**KIRKLEES METROPOLITAN COUNCIL
INVESTMENT & REGENERATION SERVICE**

DELEGATED DECISION TO DETERMINE PLANNING APPLICATIONS

Reference No:	2024/62/93193/E
Site Address:	19, Hawthorn Avenue, Batley, WF17 7BT
Description:	Erection of single storey side extension and alterations
Recommending Officer:	Joshua Merriman

HOUSEHOLDER DELEGATED REPORT

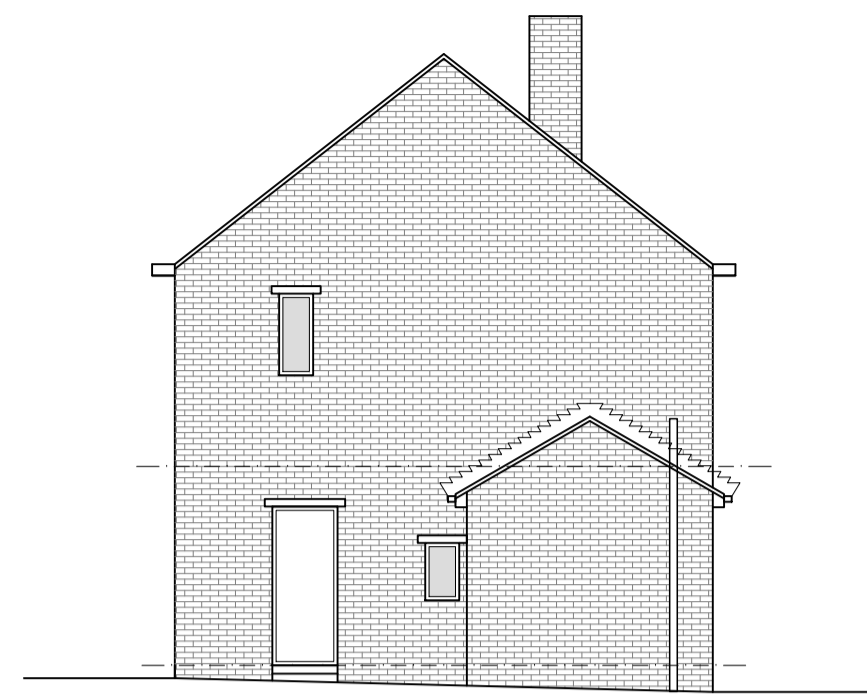
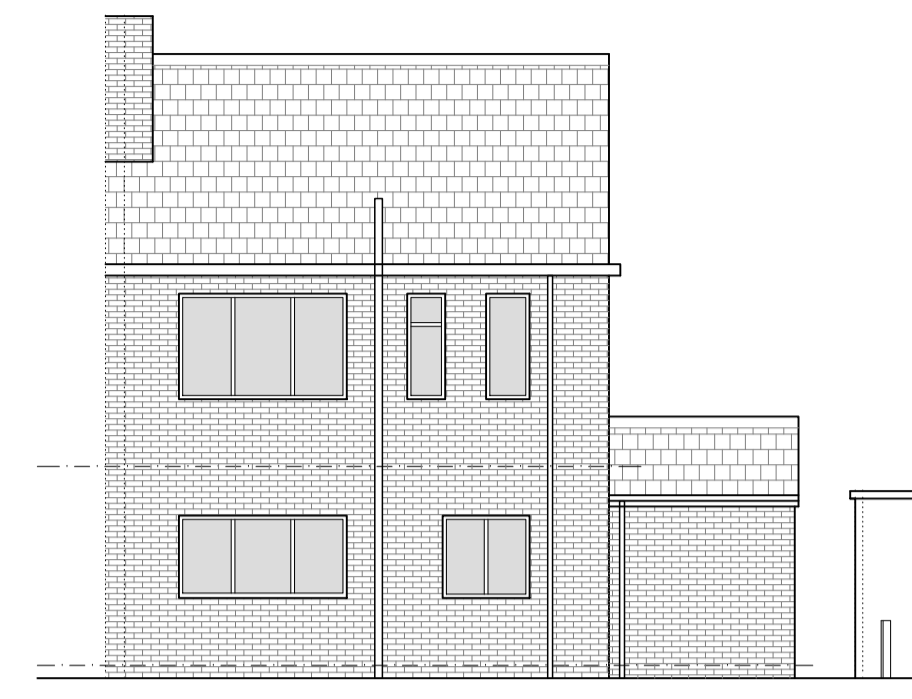
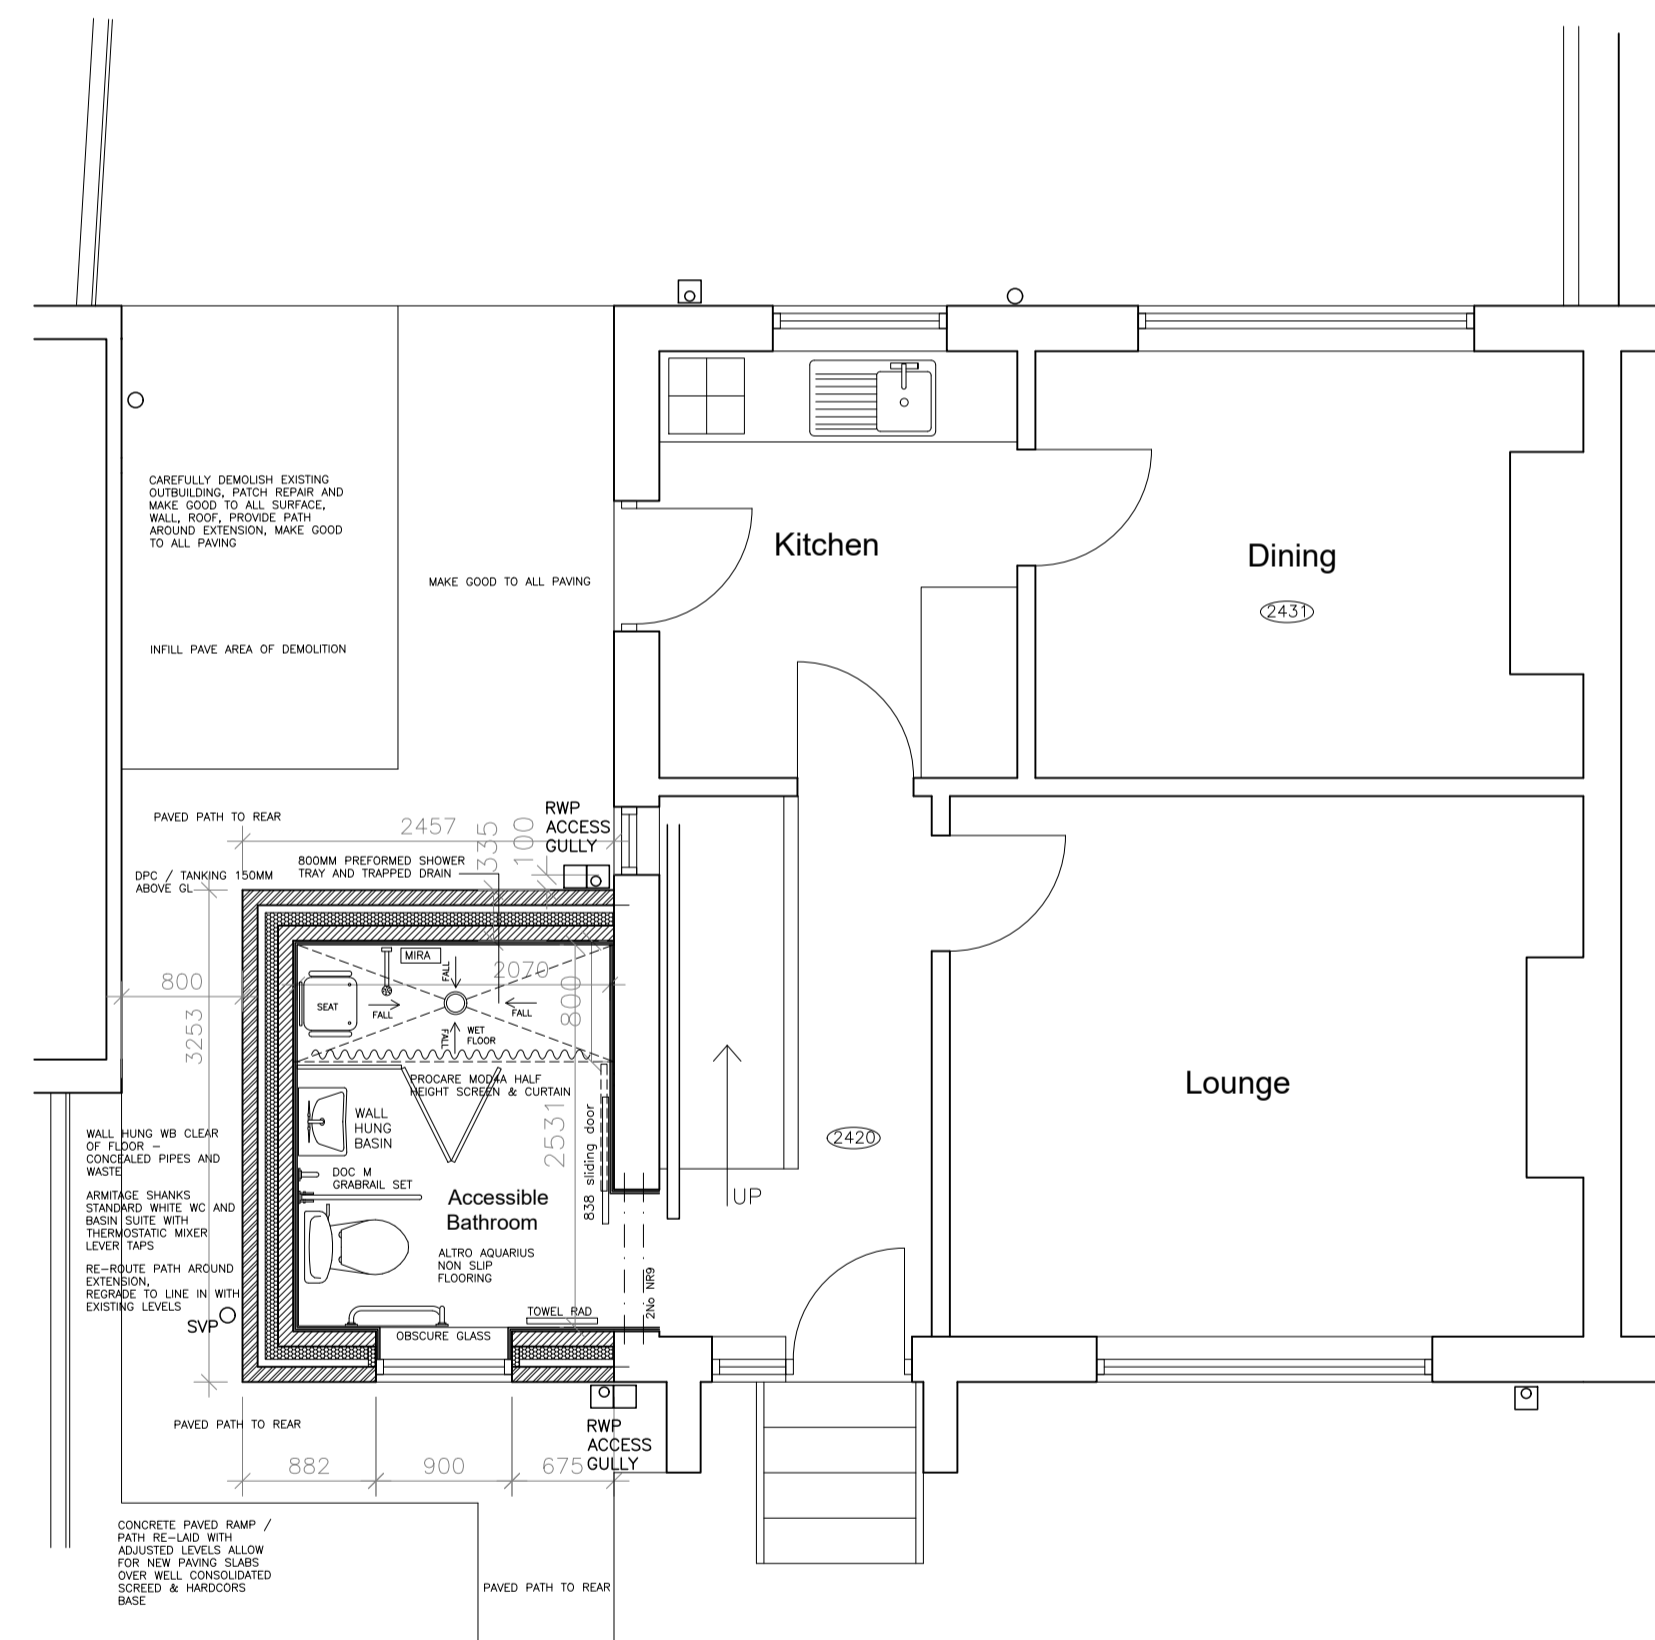
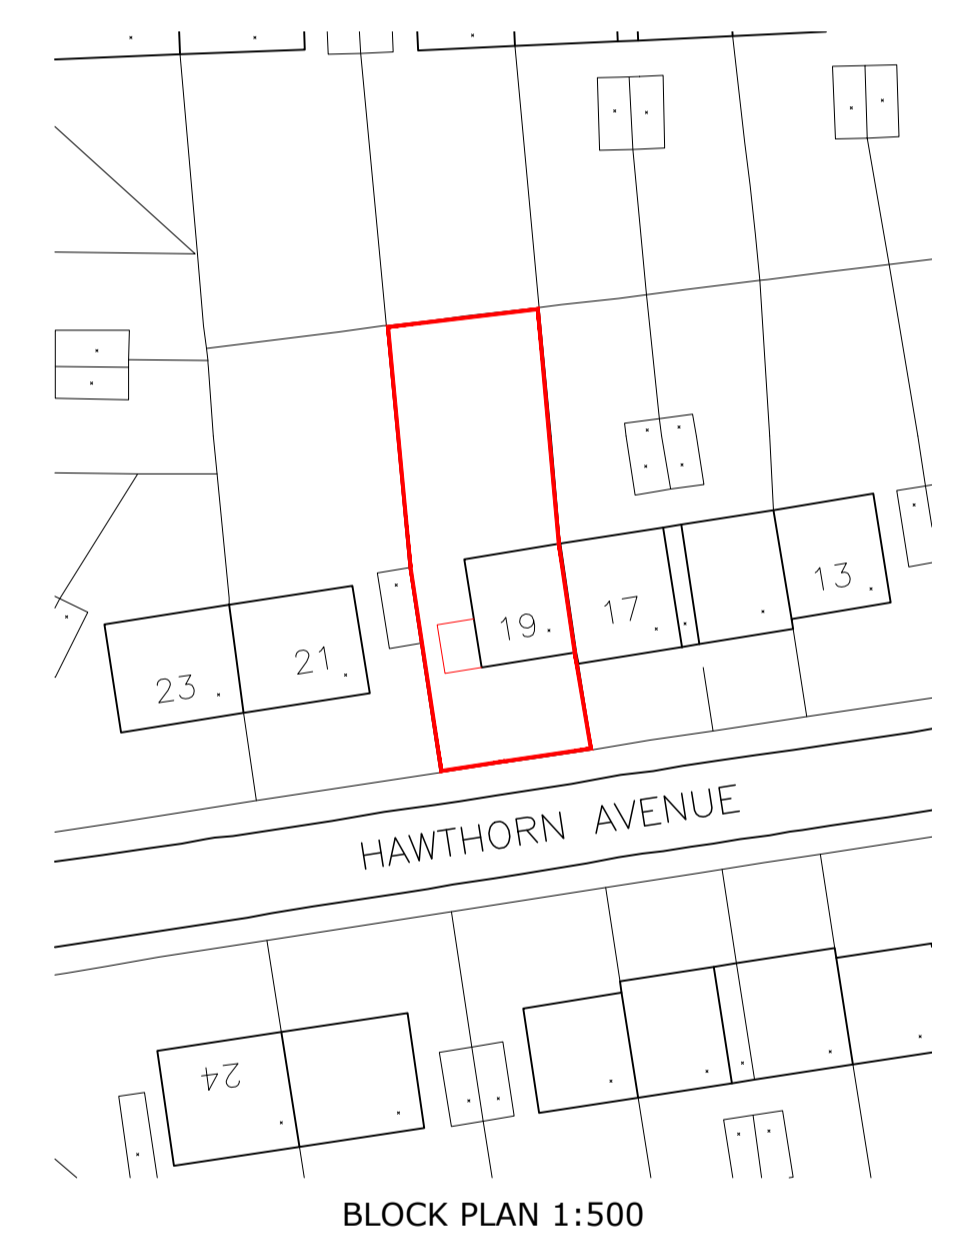
The proposed side extension is proposed to project 2.48m from the side elevation of the original building, with a maximum height of 3.56m, eaves height of 2.44m, and a depth of 3.29m.

Ensure reasonable levels of natural light to the habitable rooms in neighbouring properties	Due to the limited scale of the proposed extension, there will be no significant effect on natural light to habitable rooms in the neighbouring property.	
Positioning windows to minimise or avoid any potential overlook into neighbouring gardens	There are no proposed side or rear windows in the extension, therefore, it is considered that no overlooking into neighbouring properties will be facilitated. The proposed ensuite window in the front elevation will need to be obscured as per the condition added to the end of the report to prevent conflict with opposing neighbours.	
Single storey side extensions should:		
not extend more than two thirds of the width of the original house	The extension does not extend more than two thirds of the width of the original house.	
not exceed a height of 4 metres	The maximum height of the extension is 3.56m.

be set back at least 500mm from the original building line to allow for a visual break		The proposal is set to lie flush with the front elevation of the property, however, due to the location within an existing row of terraced properties this design

will not detract from the street scene, and is considered acceptable.
--	--	---

Relevant key design principle (KDP) of the SPD, Policy in the Kirklees Local Plan and the NPPF	Further comments	✓ / X / N/A
Impact on the Local character and street scene	• KDP1 of the SPD • Policy LP24 Design (a) and (c) of the KLP • Chapter 12 NPPF	As the extension is subservient to the original building and is to be constructed using materials to match the existing property, it is considered that there will be no significant impact on the local character or street scene.	✓
Impact on original house	• KDP2 of the SPD • Policy LP24 Design (c) and (d) of the KLP • Chapter 12 of the NPPF	Due to the limited scale of the proposal, there will be no significant impact on the original house.	✓

Height, scale and massing	• KDP 1 and 2 of the SPD • Policy LP24 Design (a), (c) and (d) of the KLP • Chapter 12 of the NPPF	The extension is subservient to the original building in terms of height, scale, and massing.	✓
Facing materials and detailing	• KDP 9 of the SPD • Policy LP24 Design (d) (iii) of the KLP • Chapter 12 of the NPPF	The walls of the extension are proposed to be constructed using brickwork to match the existing building.	✓
Roof style	• KDP 1 and 2 of the SPD • Policy LP24 Design (a), (c) and (d) of the KLP • Chapter 12 of the NPPF	The roof is to be constructed using tiles to match the original dwelling.	✓
Window proportions	• KDP 1 and 2 of the SPD • Policy LP24 Design (a), (c) and (d) of the KLP • Chapter 12 of the NPPF	The window proposed in the front elevation is proportionate to those existing in terms of size and positioning.	✓
Accessibility for all users	• KDP 17 of the SPD • Policy LP24 Design (f) • Chapter 12 of the NPPF	Private domestic extension – no alternate access arrangements required.	✓

Relevant key design principle (KDP) of the SPD, Policy in the Kirklees Local Plan and the NPPF	Further comments	✓ / X / N/A
Impact on privacy of neighbours (to sides, rear and front)	• KDP 3 & 4 of the SPD • Policy LP24 Design (d) (iv) • Chapter 12 of the NPPF	The only window in the extension will be conditioned to be obscured as it is an ensuite window, therefore, it is considered there will be no significant impact on the privacy of neighbours.	✓
Impact on light and outlook of neighbours (to sides, rear and front)	• KDP 4, 5, 6 of the SPD • Policy LP24 Design (b) • Chapter 12 of the NPPF	Due to the limited scale of the extension, there will be no significant impact on light and outlook of neighbouring properties.	✓
Impact on overbearing or overshadowing	• KDP 5, 6 of the SPD • Policy LP24 Design (b)	As aforementioned, due to the limited scale of the proposal there will be no significant impact in	✓

3. The development shall be completed using materials to match and thereafter be retained.
